**From:** Patel, Uday [Uday.Patel@lancashire.gov.uk]  
**Sent:** 12 August 2014 12:46  
**To:** planning  
**Cc:** ENV LHS Customer Service  
**Subject:** 3/2014/0592 - Proposed demolition of the Moorcock Inn and the erection of 7no dwelling houses including associated drives, gardens and external landscaping works - The Moorcock Inn Slaidburn Road Waddington

**Planning Application Reference:** 3/2014/0592

**Proposal:** Proposed demolition of the Moorcock Inn and the erection of 7no dwelling houses including associated drives, gardens and external landscaping works

**Location:** The Moorcock Inn Slaidburn Road Waddington

Drawing Title PROPOSED ROOF PLAN		
Scale 1:200 @ A1	Date JUNE 2014	Drawn TB

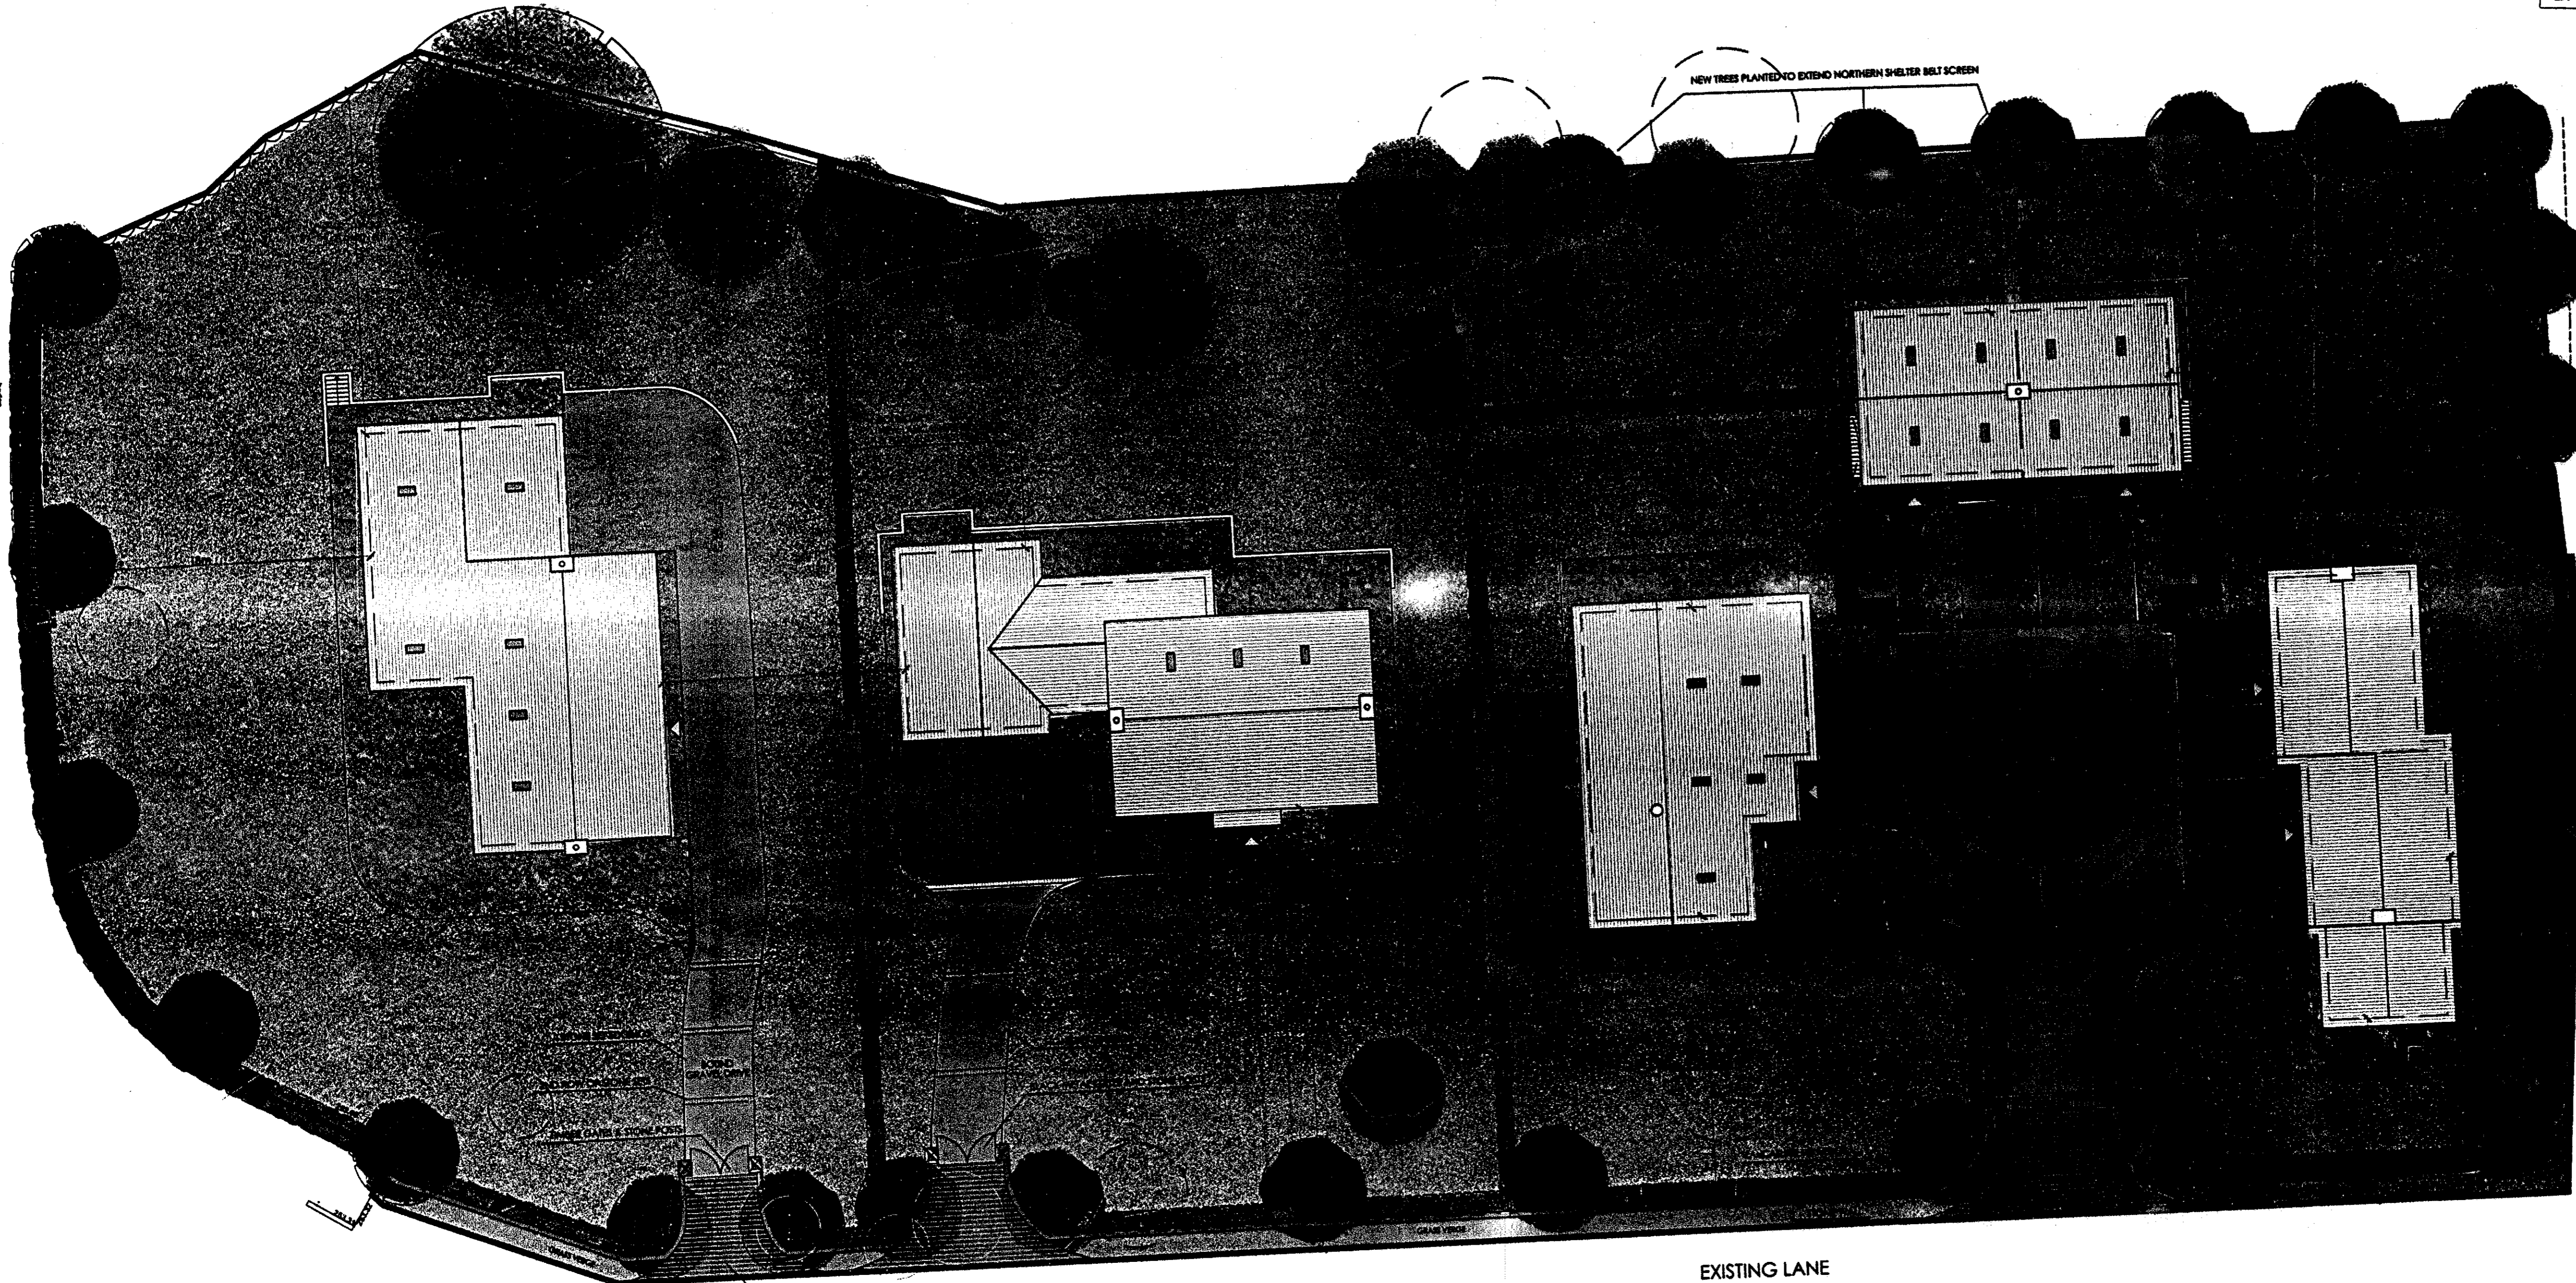
Proposed development is erection of 7 dwellings on the site. Two houses will be of two bedroom, two houses will be of three bed room and three houses will be of four bedroom each. Existing access to the property from Slaidburn Road will remain same. However there will be a road along the frontage of the property which will lead to drive way/access to each houses separately. Thus there is no separate access from Slaidburn road individually to each house.

According to JLSP residential parking standard guidelines, two bedroom dwelling shall require one parking space, three bedroom dwelling will require two parking spaces and three bed room dwelling will require three parking spaces within curtilage of each property. The layout indicates that appropriate paring provision if provided for each of the dwelling to accommodate domestic vehicles associated with the house within curtilage of the property.

Highway' traffic point of view proposed development is considered to be contributing significantly less vehicles and there by less traffic to the existing road network. This situation is considered to be significant improvement highways point of view. All the properties are accessible via access road where there is very less traffic, or if any, will be associated with the proposed properties. There is likely to be very less speed of the vehicles on the access road. Thus visibility is not a major issue for each property. It is necessary that access road is appropriately surfaced with hard standing material so that no loose material is spilled over on to the Slaidburn Road.

There is no objection to the proposed development on highway grounds.
